9200 S.E. 57<sup>th</sup> Street  
Mercer Island, Washington 98040  
July 5, 2017

Re: Comment to Application SEP 15-001

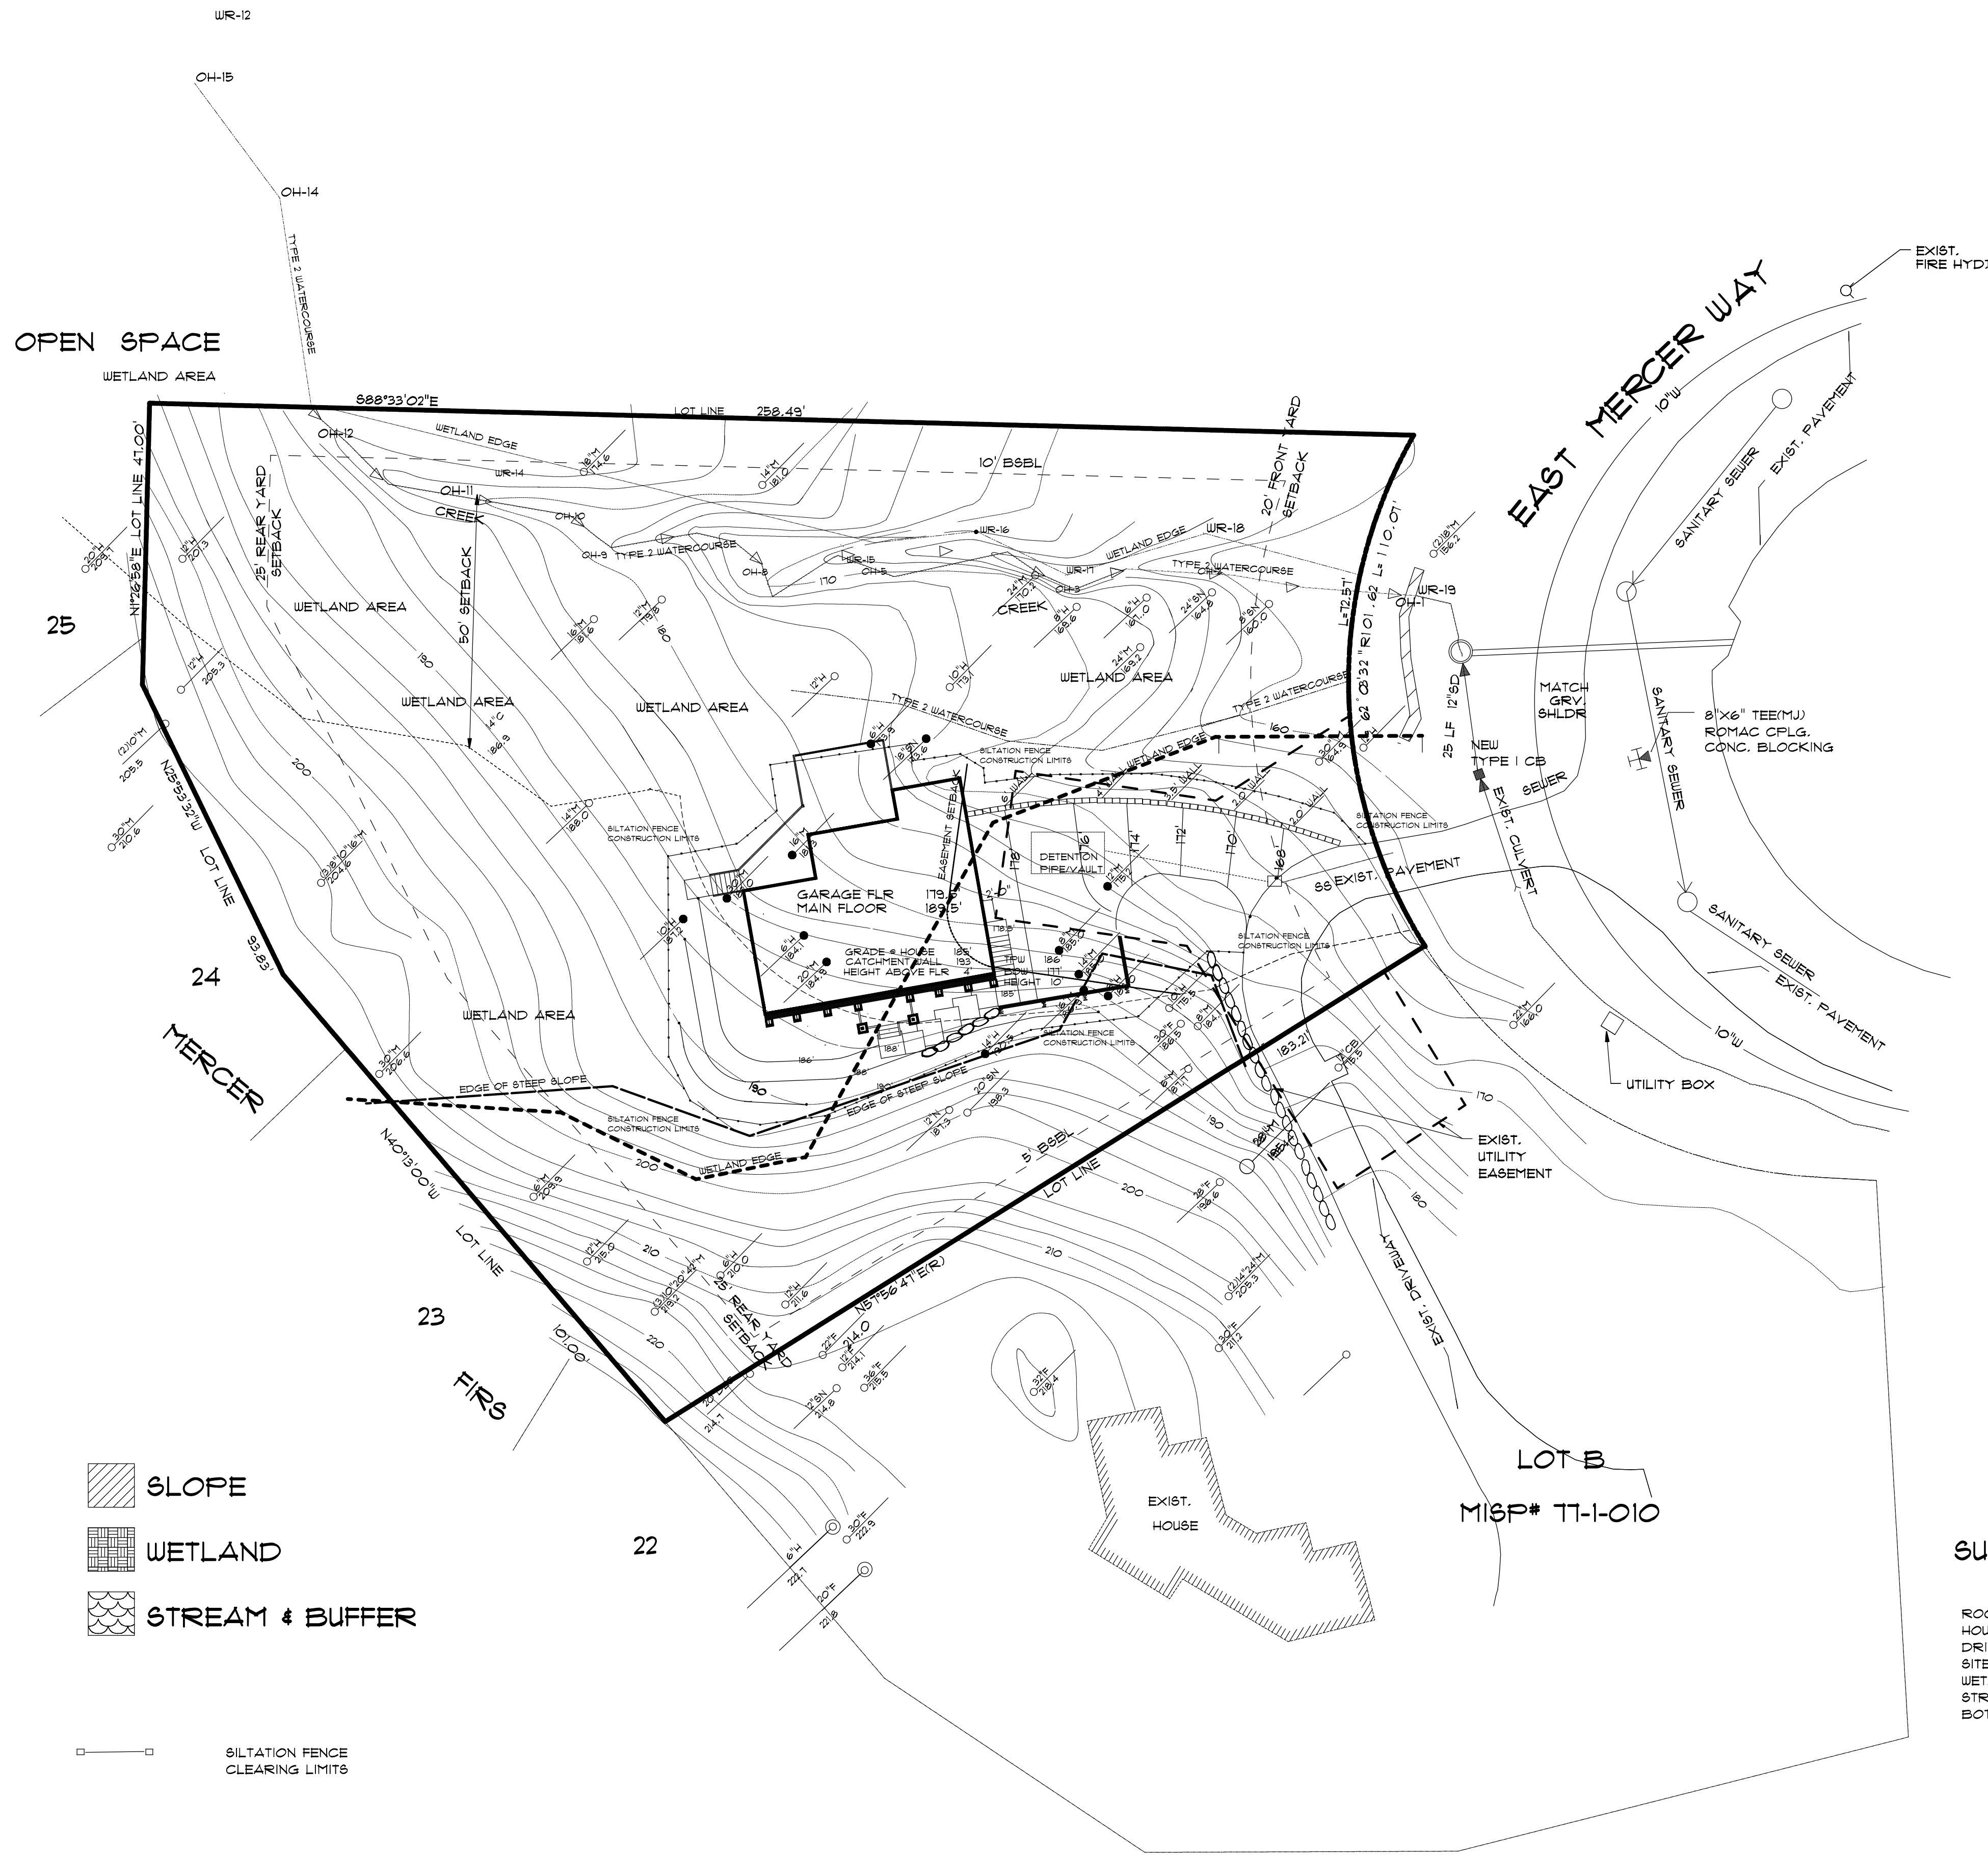
Section B(3)(c)(i) of the checklist relates to “water runoff including stormwater.” Applicant responds: “Roofs and driveway runoff will be collected and stored in a detention vault with discharge metered to flow into existing watercourse.” This statement is not consistent with the actual plans submitted by the applicant. The proposed detention vault is located at the top of the driveway which slopes downward. According to the plans, there is a catch basin at bottom of the driveway which is channeled directly into the watercourse without passing through the detention vault. Because of the slope, it appears that most, if not all, of the water falling on the driveway will not pass through the detention vault. In addition the size of the detention vault in the plans is much smaller that the size required by applicant’s downstream expert Triad. Applicant’s response also does not address the additional runoff caused by the removal of trees.
